Gatwick Airport Northern Runway
National Infrastructure Project
TR020005

Relevant Representation Submission

27th October 2023

Title:
Ordnance Survey Base Map Identifying Category 3 and Noise Insulation Scheme Boundary - Sheet 1 of 4

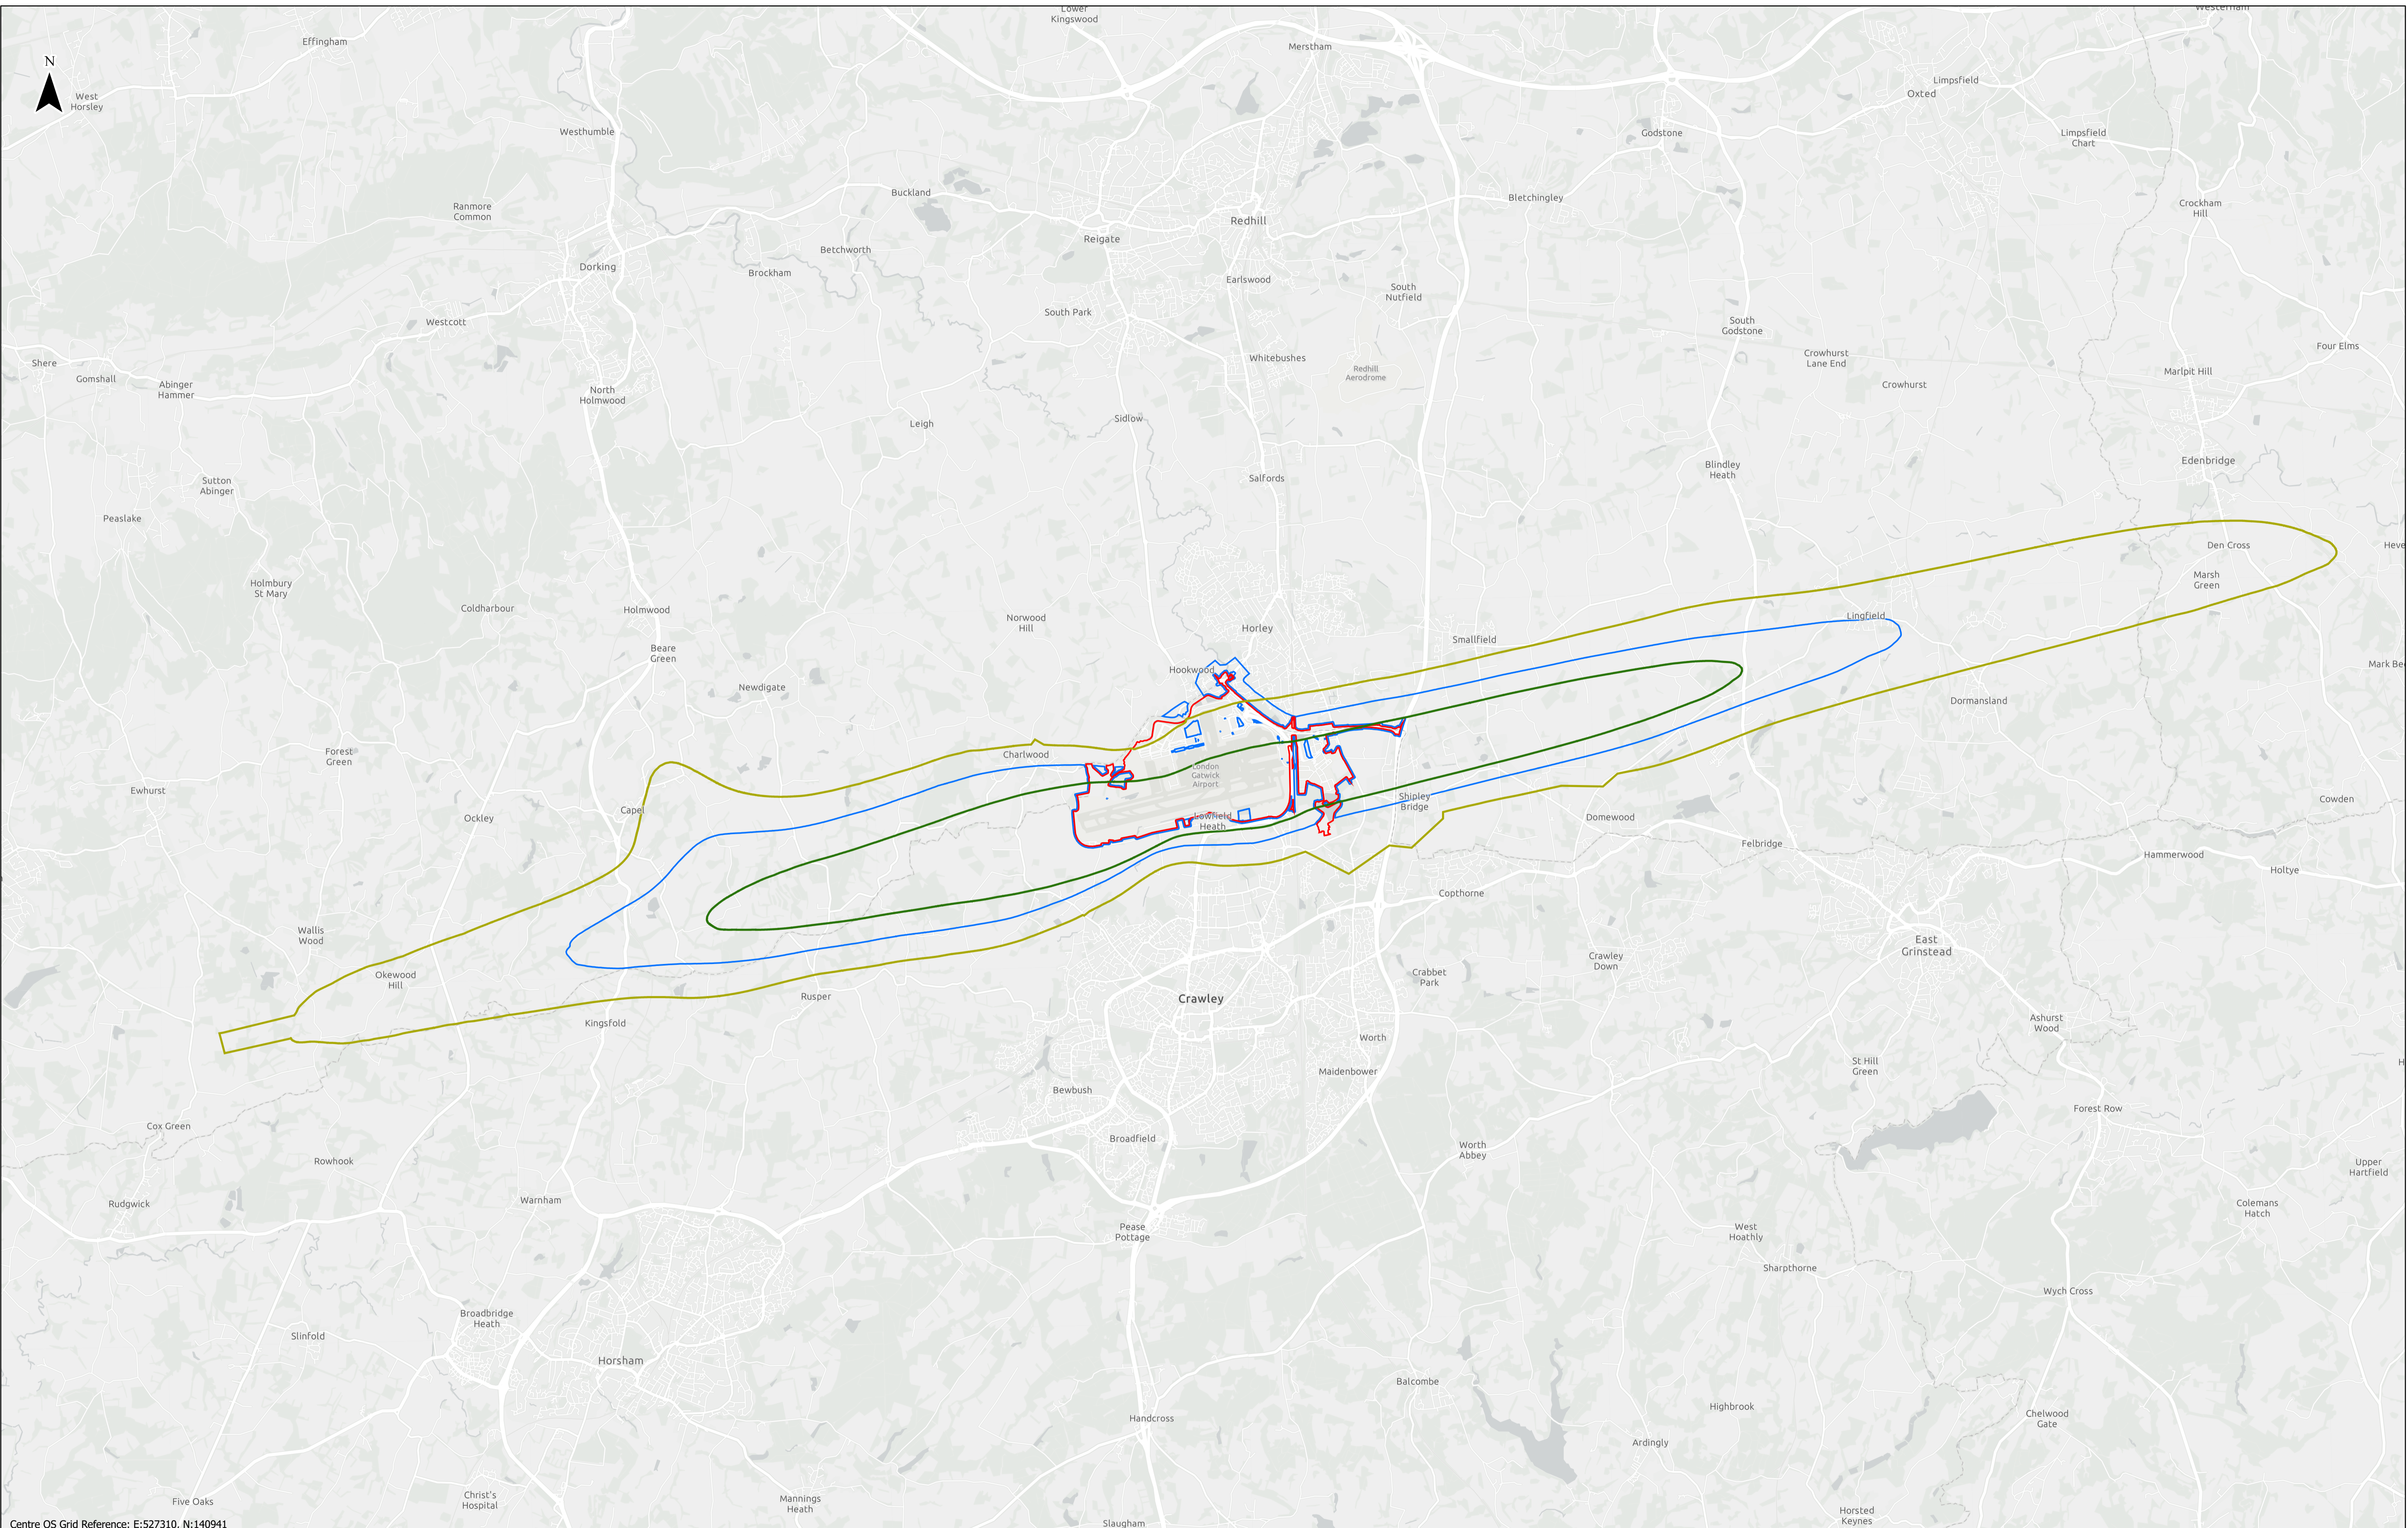
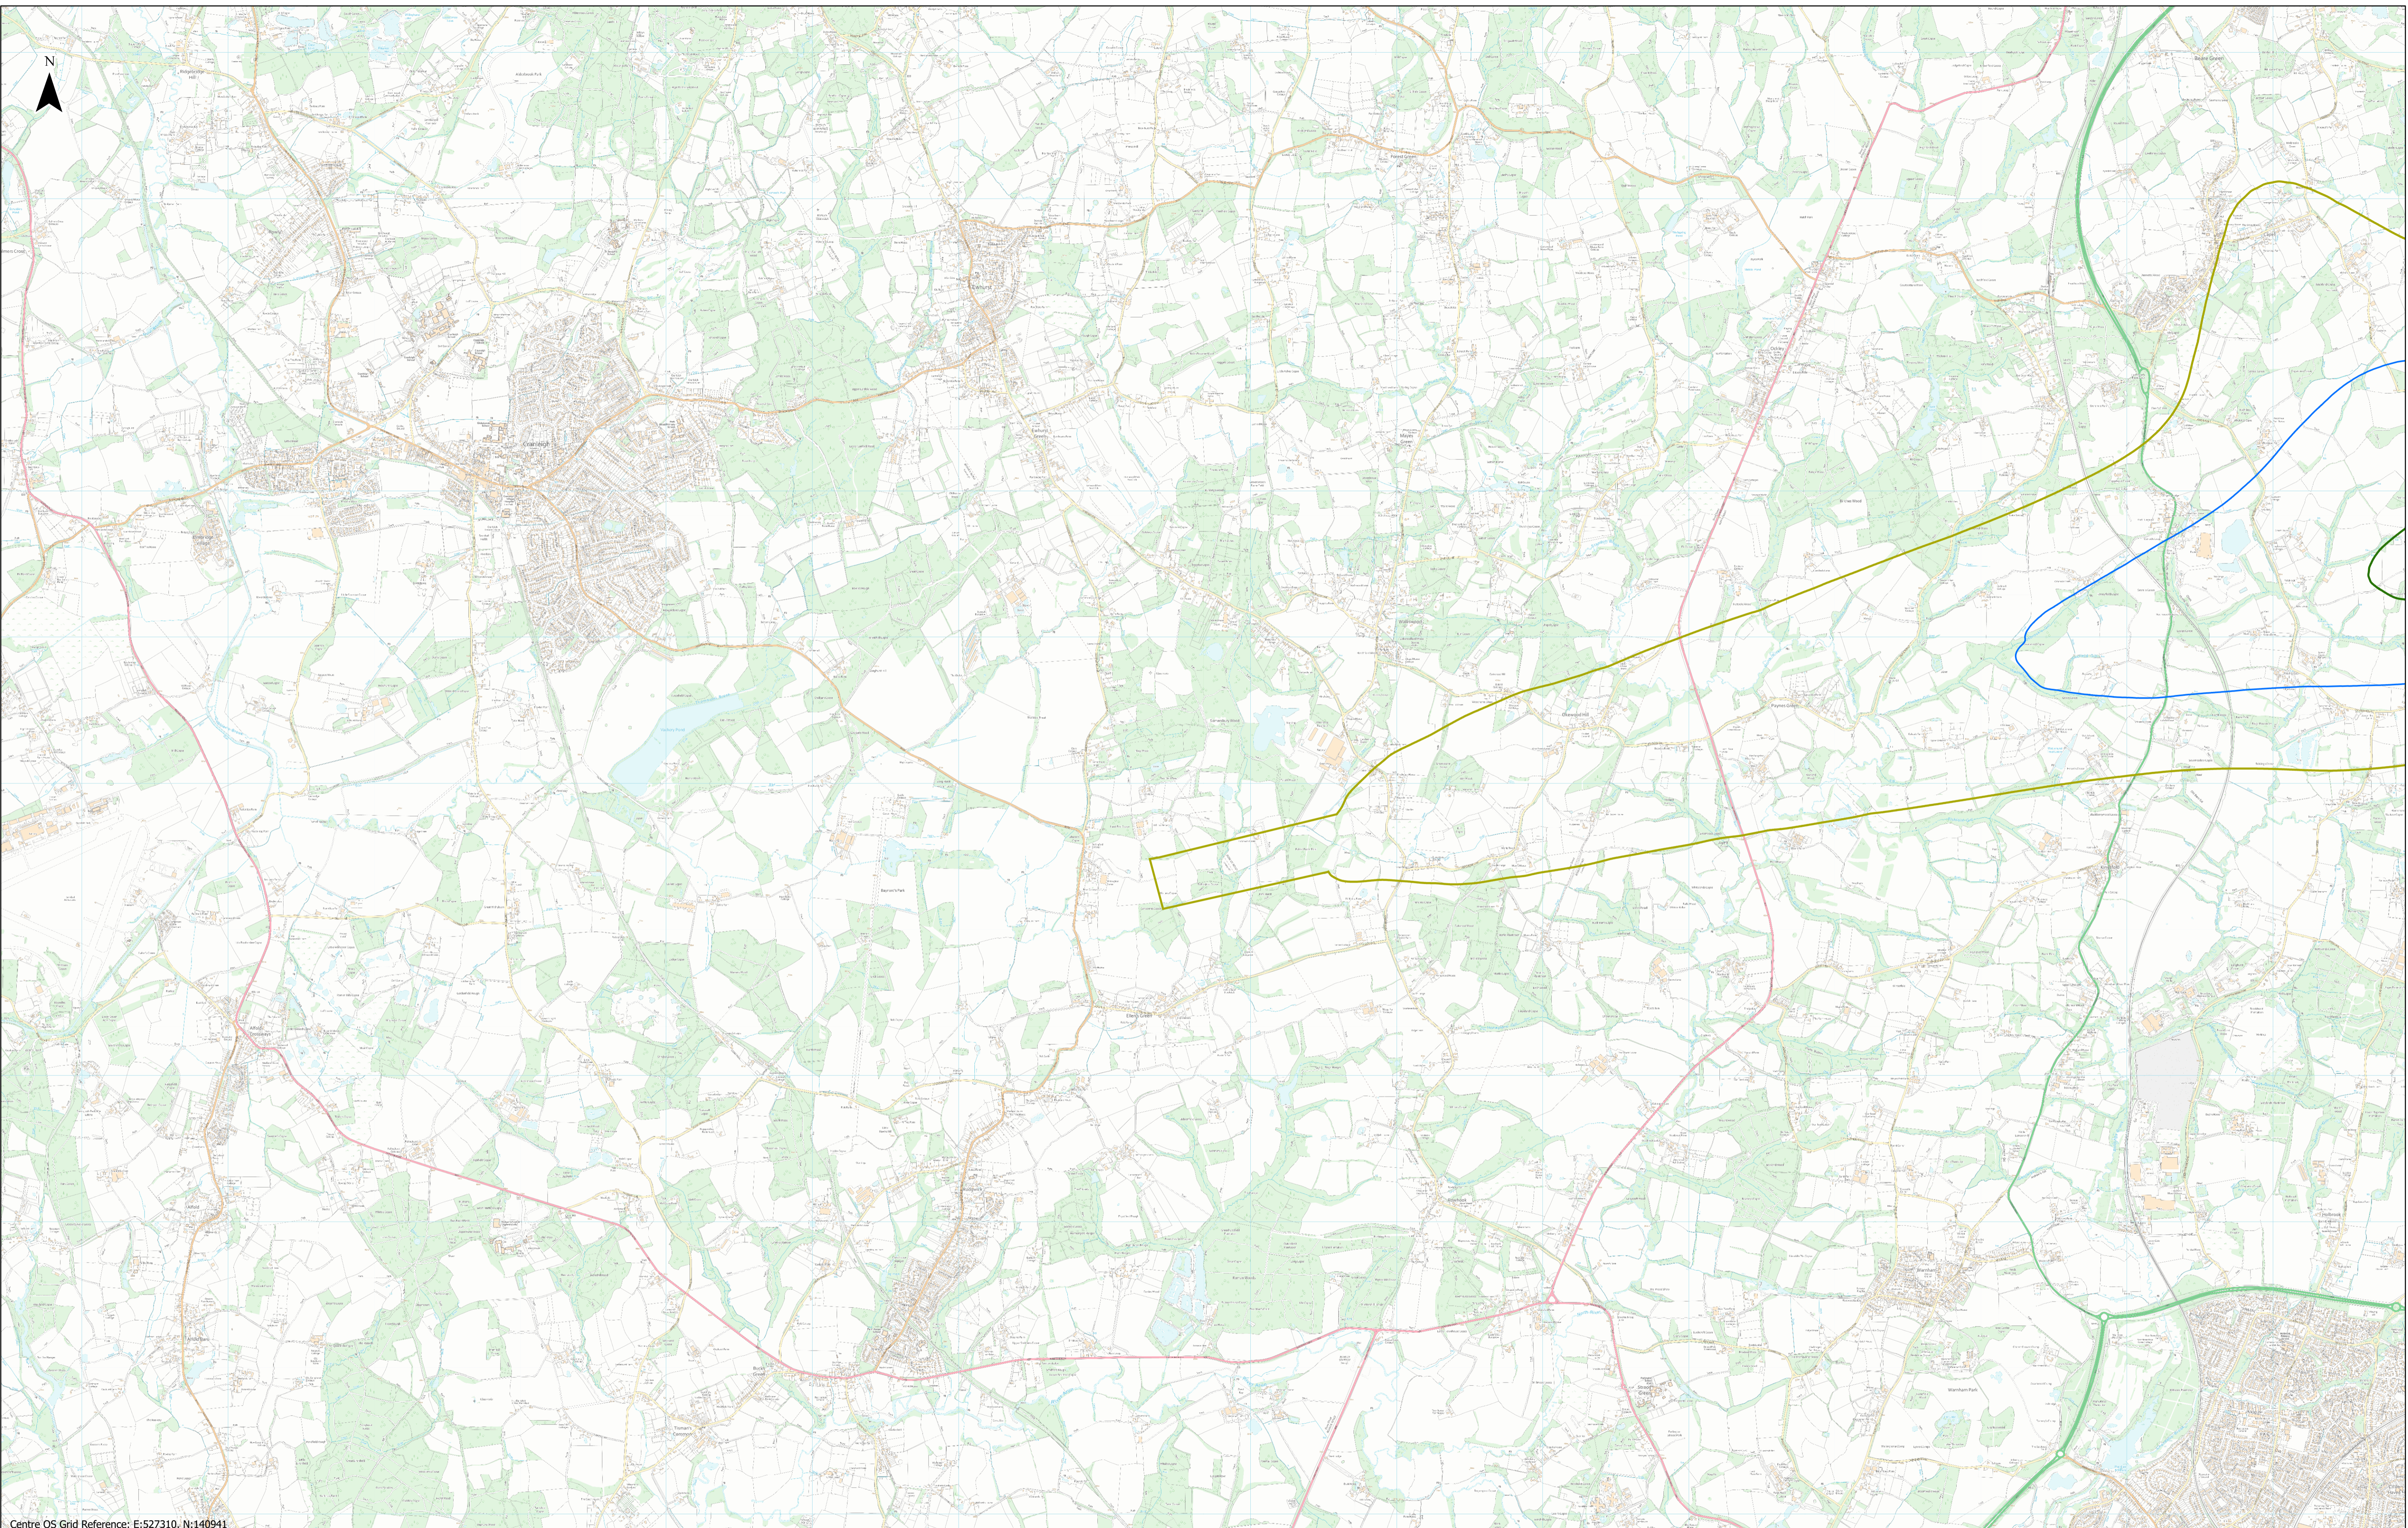
- a. Residents of properties within the inner zone will be notified within 6 months of commencement of works; however, the noise contours on which eligibility would be based upon are not clear.
- b. Residents in the outer zone should be offered more flexibility on the type of insulation rather than being restricted to ventilation.
- c. The noise insulation scheme should extend to community buildings (e.g. care homes, places of worship, village halls, hospitals etc.).

- d. It is not clear if properties that have already received insulation would be eligible for upgraded noise insulation as part of the new scheme.
- e. No details are provided on how monitoring of ground noise would be undertaken and how a property would be identified as appropriate for monitoring ground noise.
